Jeanie Bourke - 263 Brighton Ave., BP#2015-02710 fire separation update

From: Jeanie Bourke
To: Dave; Ellen Hayes; kim.marquis@store.lowes.com
Subject: 263 Brighton Ave., BP#2015-02710 fire separation update
CC: Douglas Morin

# BASEMENT

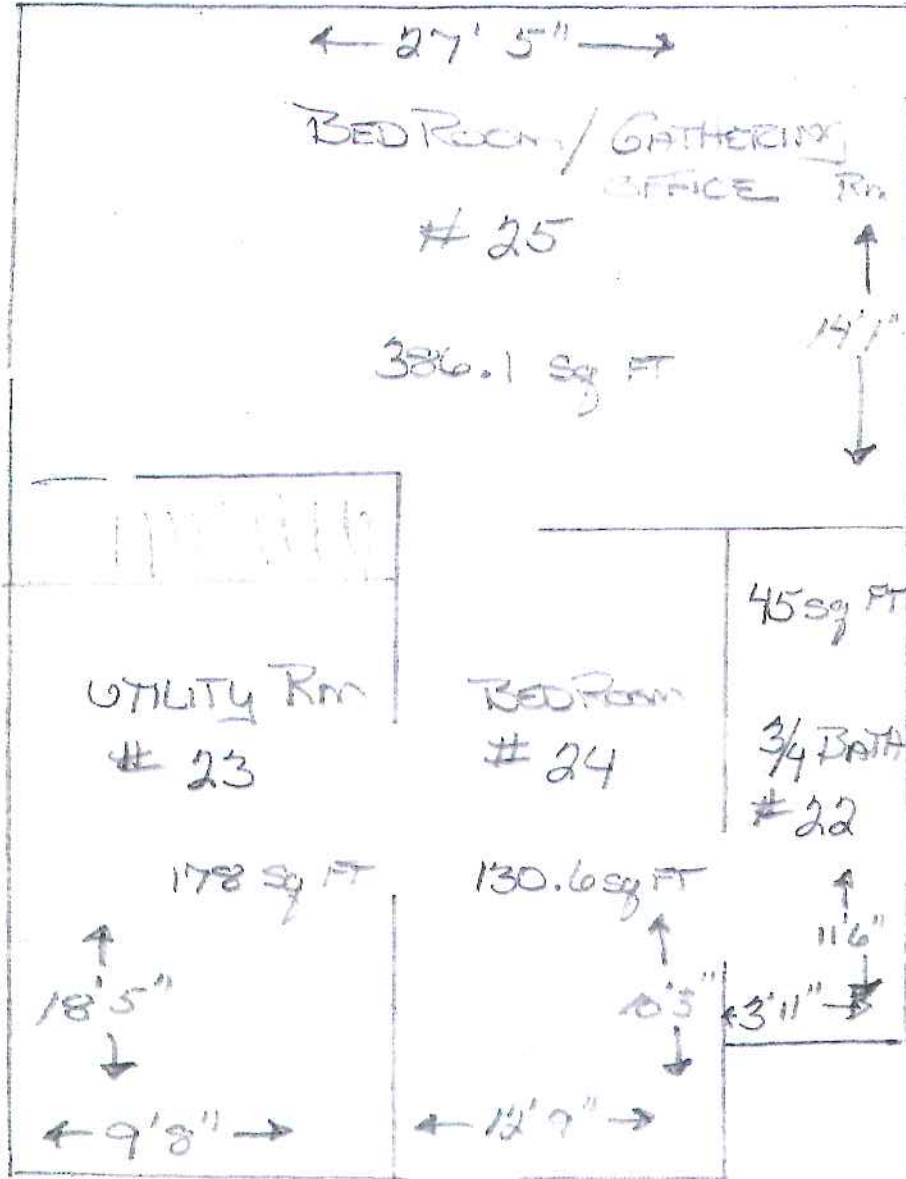
It has come to my attention that there is a suspended ACT ceiling in the basement. Please be advised that the area below the front entry that is part of the 2nd floor unit is required to be fire separated from the 1st floor/basement unit.

This can be achieved using 5/8" firecode drywall on the ceiling, with insulation in for sound transmission. This will also need to be applied vertically between the floor joists to encapsulate the separation.
